**Application no: 22/00521/DISC**

**Location:** Sales Area, Heyford Park, Camp Road, Heyford Park, Bicester, OX25  
5HD

## **Transport Development Control**

DRAWING NO. HEYF-SK405 REV A

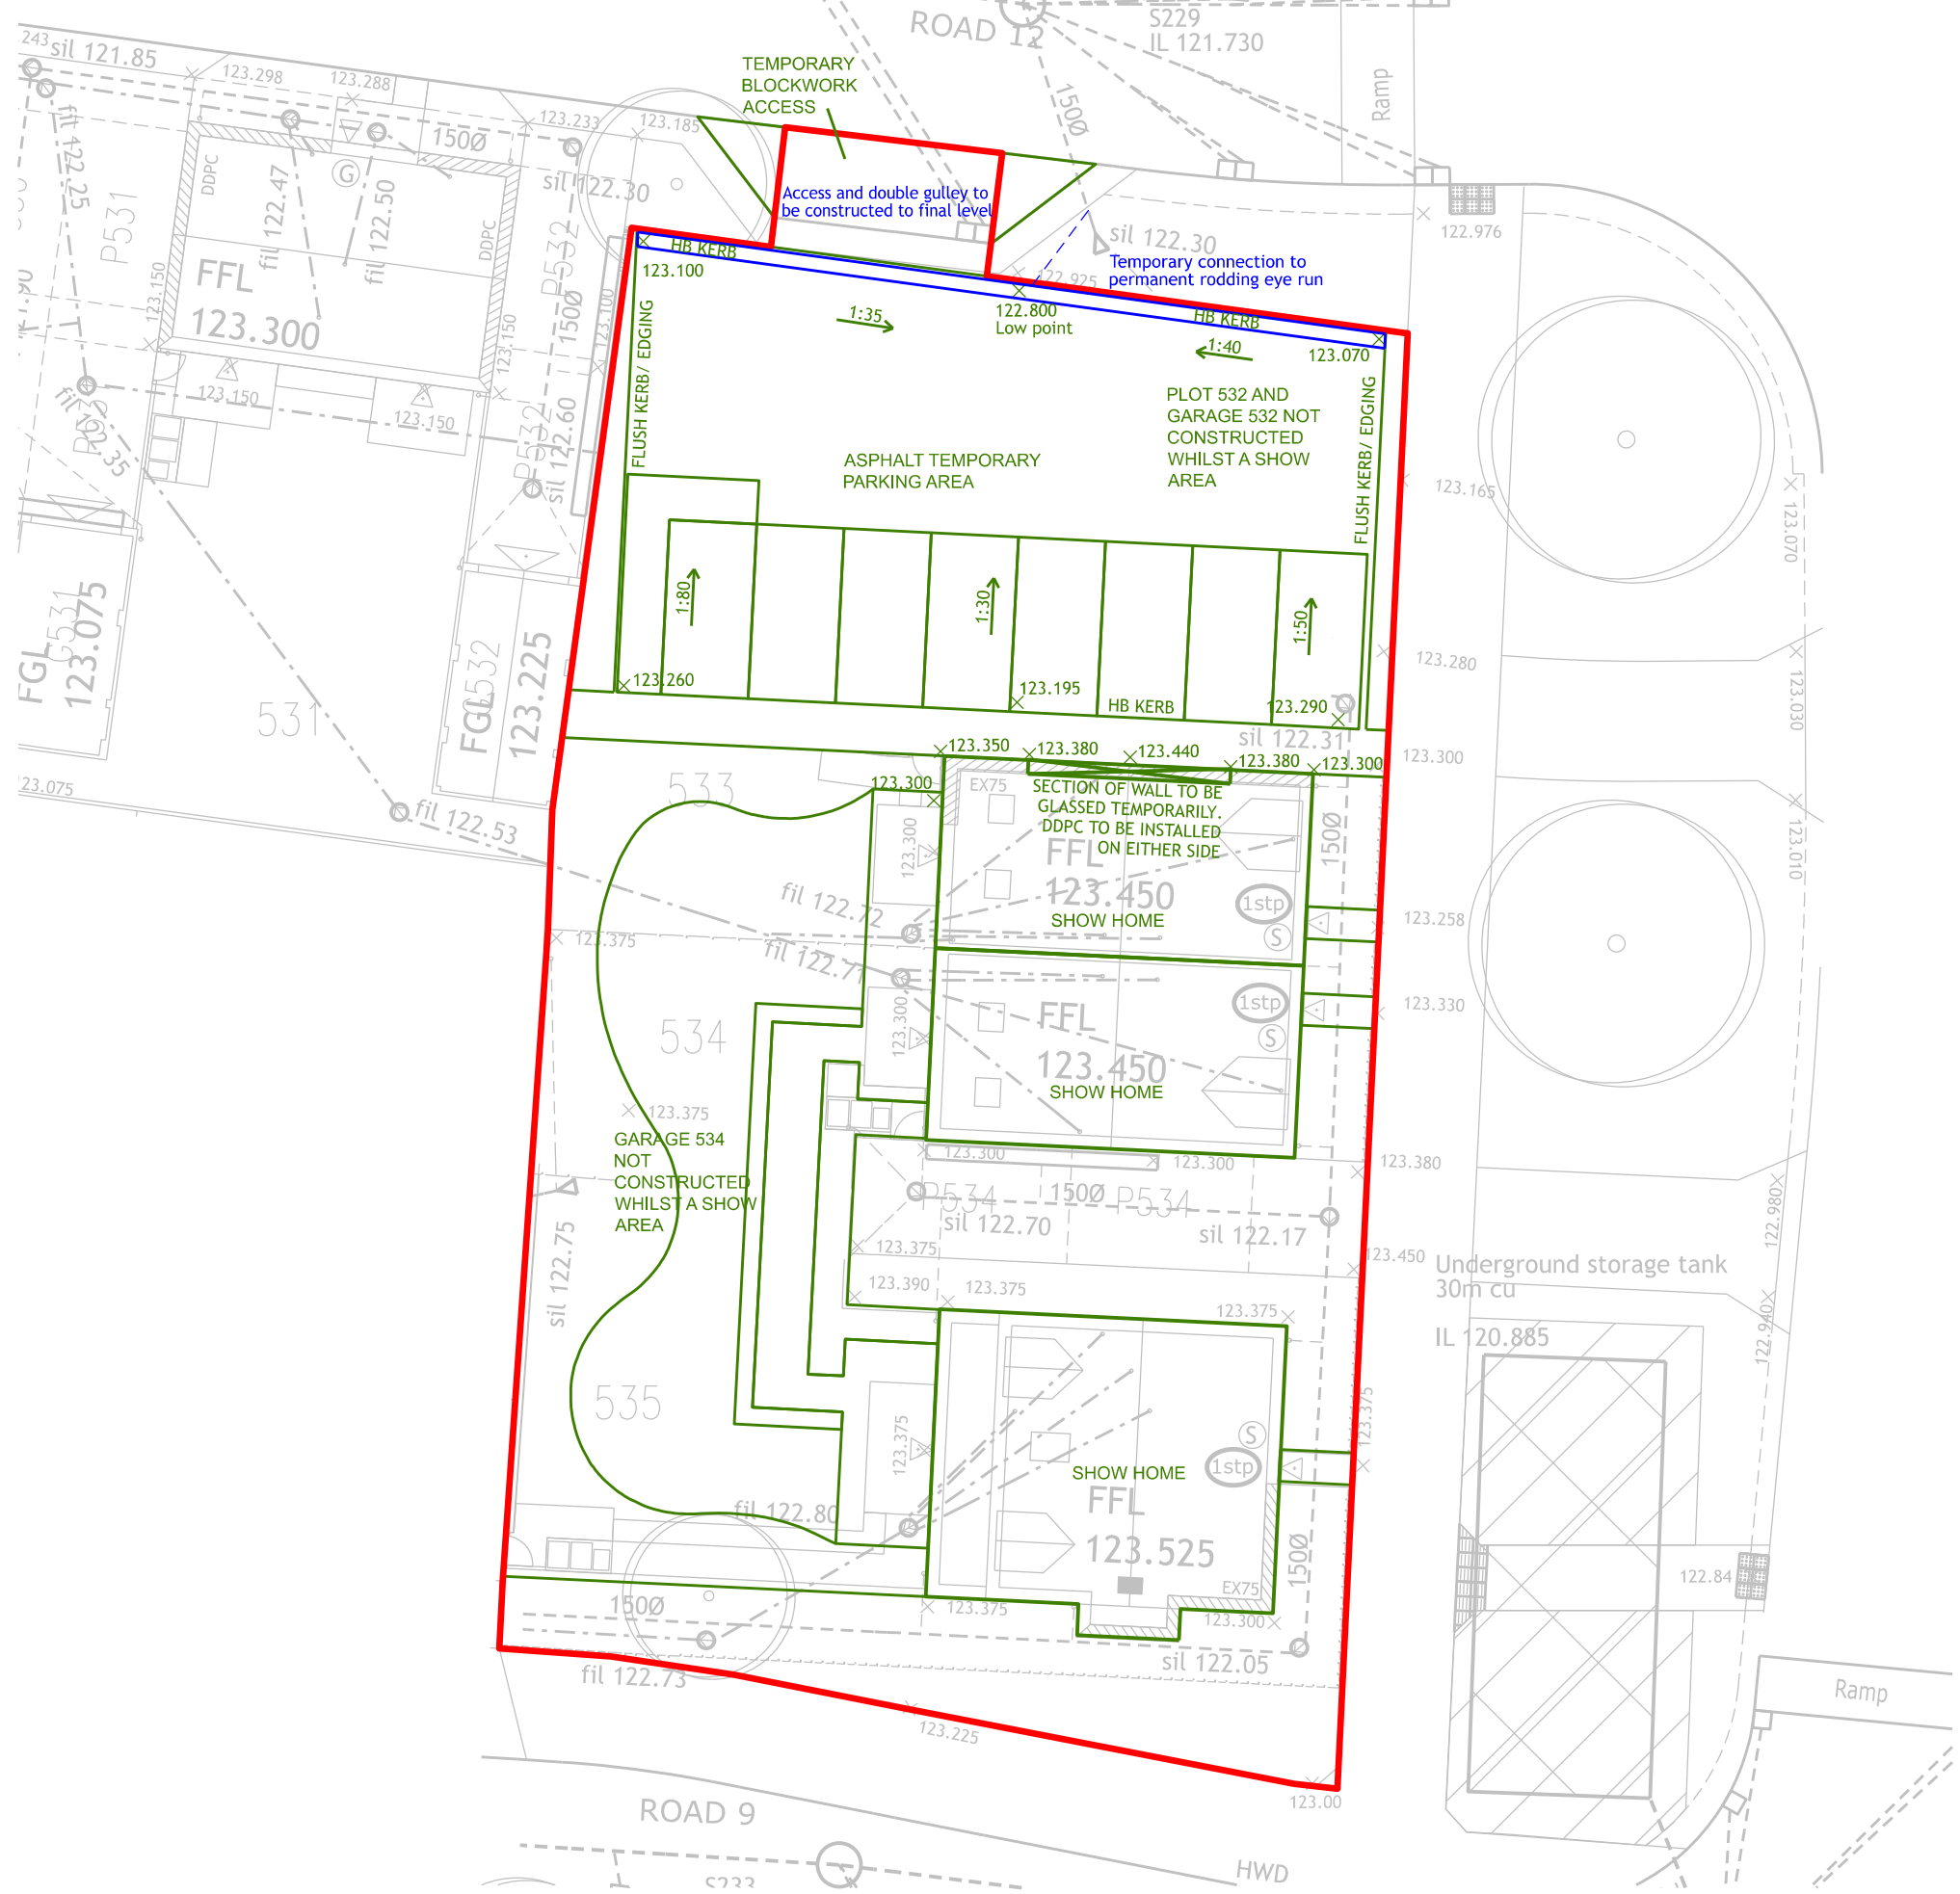
The Sales Area car park outfall drains into the private drainage, and thence to TW  
S104 drainage.

For information, the 'Temporary Blockwork Access' is part of the S38 adoption area  
– and so will need reinstating after the seven years.
